**EPC STORMWATER REVIEW COMMENTS
 IN ORANGE BOXES WITH BLACK TEXT**

EL PASO COUNTY STORMWATER MANAGEMENT PLAN CHECKLIST

EPC Project Number: **SF2427**

GRADING & EROSION CONTROL PLAN
 INITIAL & INTERIM GEC

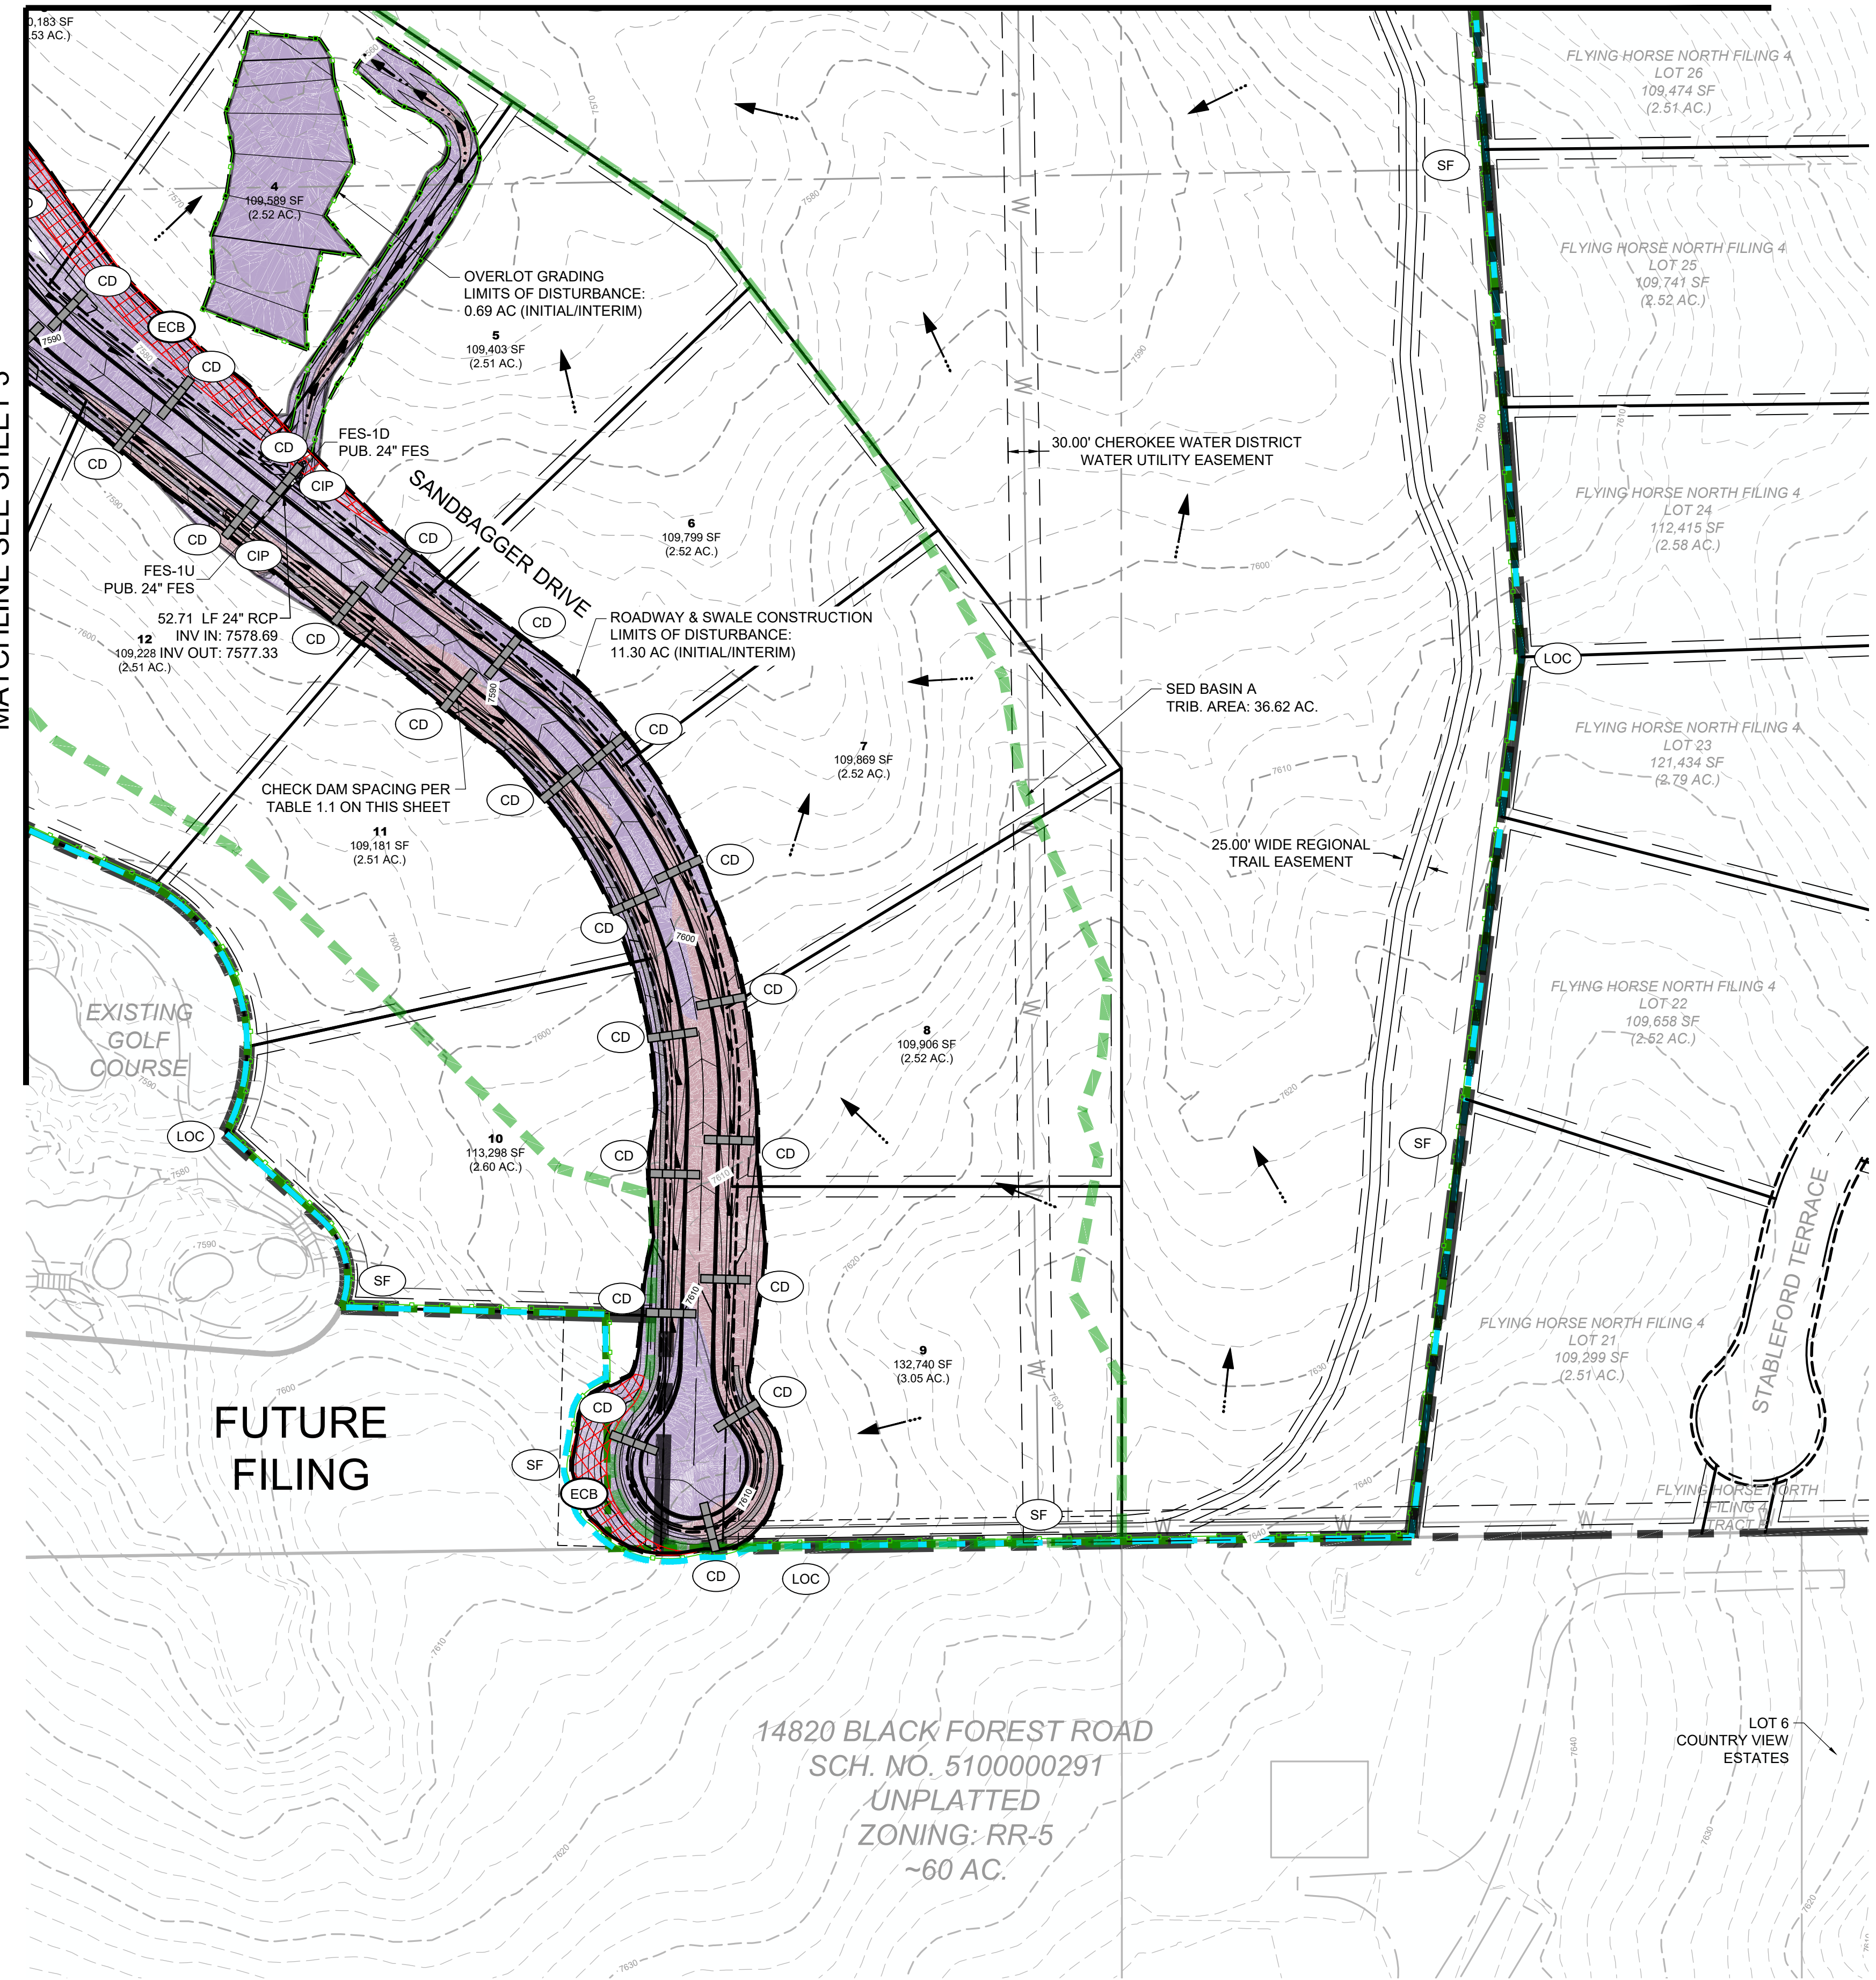
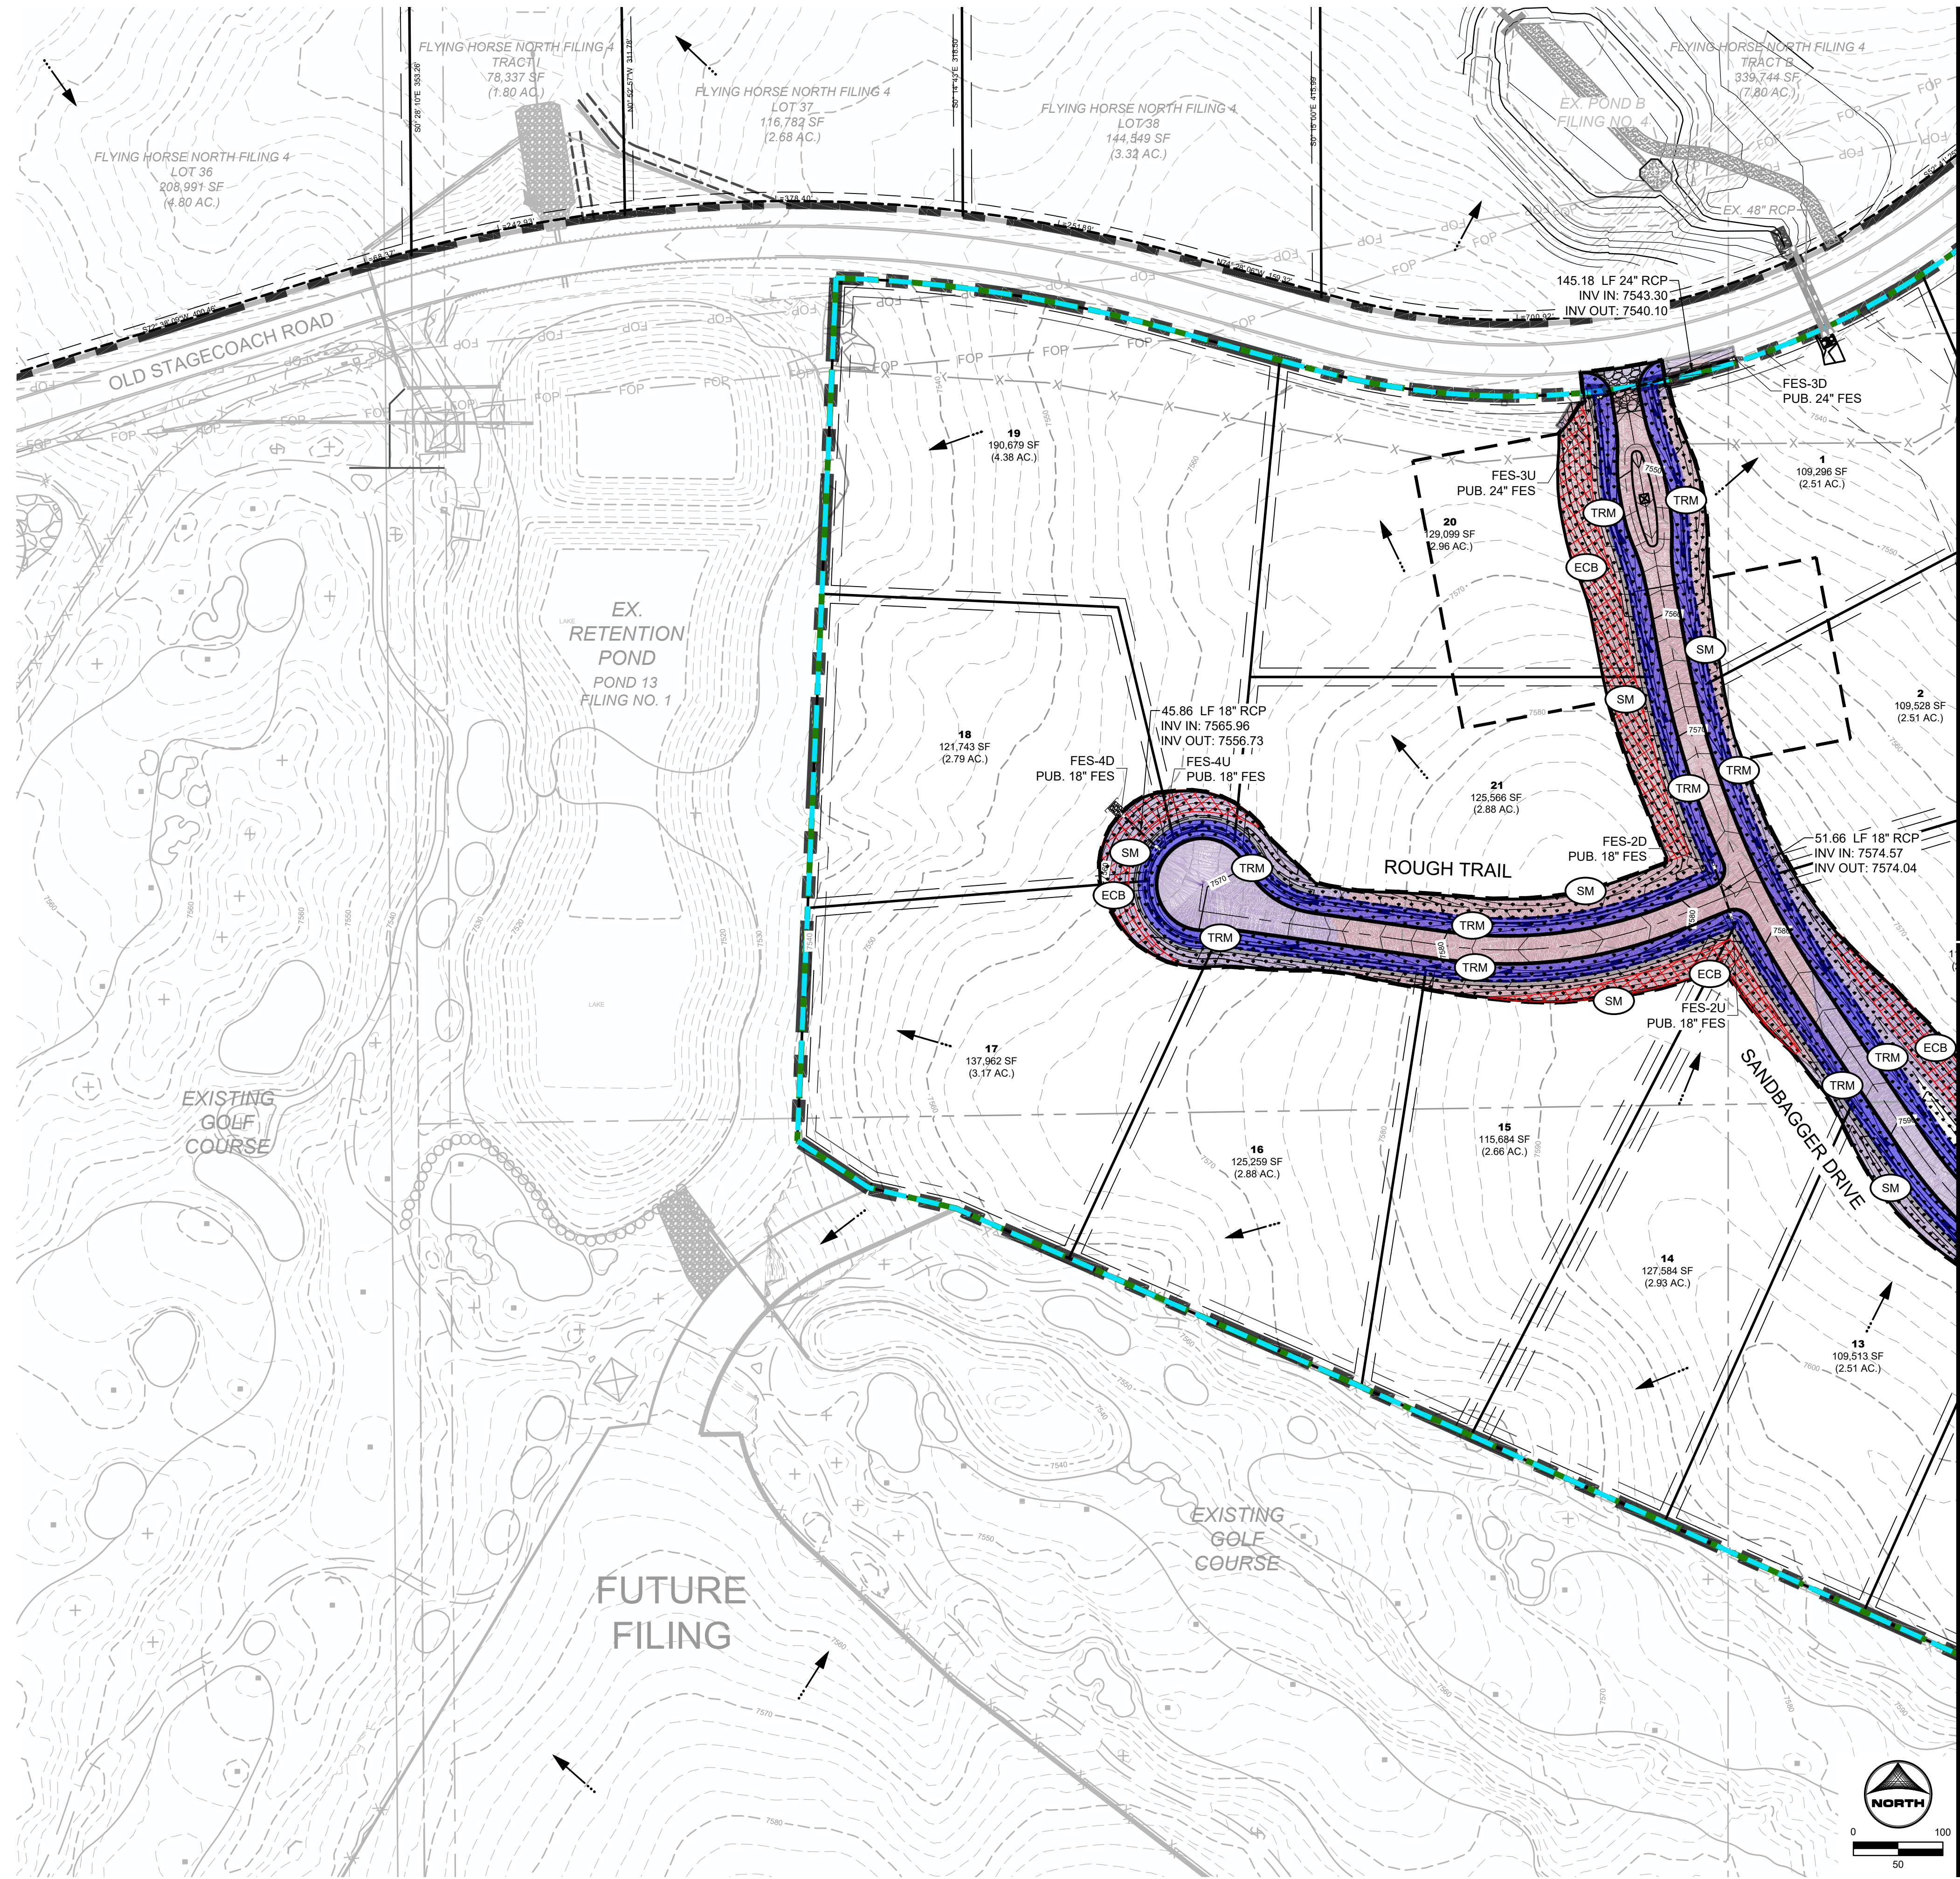
Applicant	EPC
		<small>PAGE NO.</small>	
17	SWMP Map to include: See GEC Plan Comments		
17a	construction site boundaries		Y
17b	flow arrows to depict stormwater flow directions		Y
17c	all areas of disturbance		Y
17d	areas of cut and fill		Y
17e	areas used for storage of building materials, soils (stockpiles) or wastes		Y
17f	location of any dedicated asphalt / concrete batch plants		Y
17g	location of all structural control measures		Y
17h	location of all non-structural control measures		Y
17i	springs, streams, wetlands and other surface waters, including areas that require maintenance of pre-existing vegetation within 50 feet of a receiving water		Y
18	Narrative description of all structural control measures to be used. Modifications to EPC standard control measures must meet or exceed County-approved details		Y
19	Description of all non-structural control measures to be used including seeding, mulching, protection of existing vegetation, site watering, sod placement, etc.		Y

20	Technical drawing details for all control measure installation and maintenance; custom or other jurisdiction's details used must meet or exceed EPC standards See GEC Plan comments		N
21	Procedure describing how the SWMP is to be revised		Y
22	Description of Final Stabilization and Long-term Stormwater Quality (describe nonstructural and structural measures to control SW pollutants after construction operations have been completed, including detention, water quality control measure etc.)		N
23	Specification that final vegetative cover density is to be 70% of pre-disturbed levels		Y
24	Outline of permit holder inspection procedures to install, maintain, and effectively operate control measures to manage erosion and sediment		Y
25	Record keeping procedures identified to include signature on inspection logs and location of SWMP records on-site		N
26	If this project relies on control measures owned or operated by another entity, a documented agreement must be included in the SWMP that identifies location, installation and design specifications, and maintenance requirements and responsibility of the control measure(s)		Y
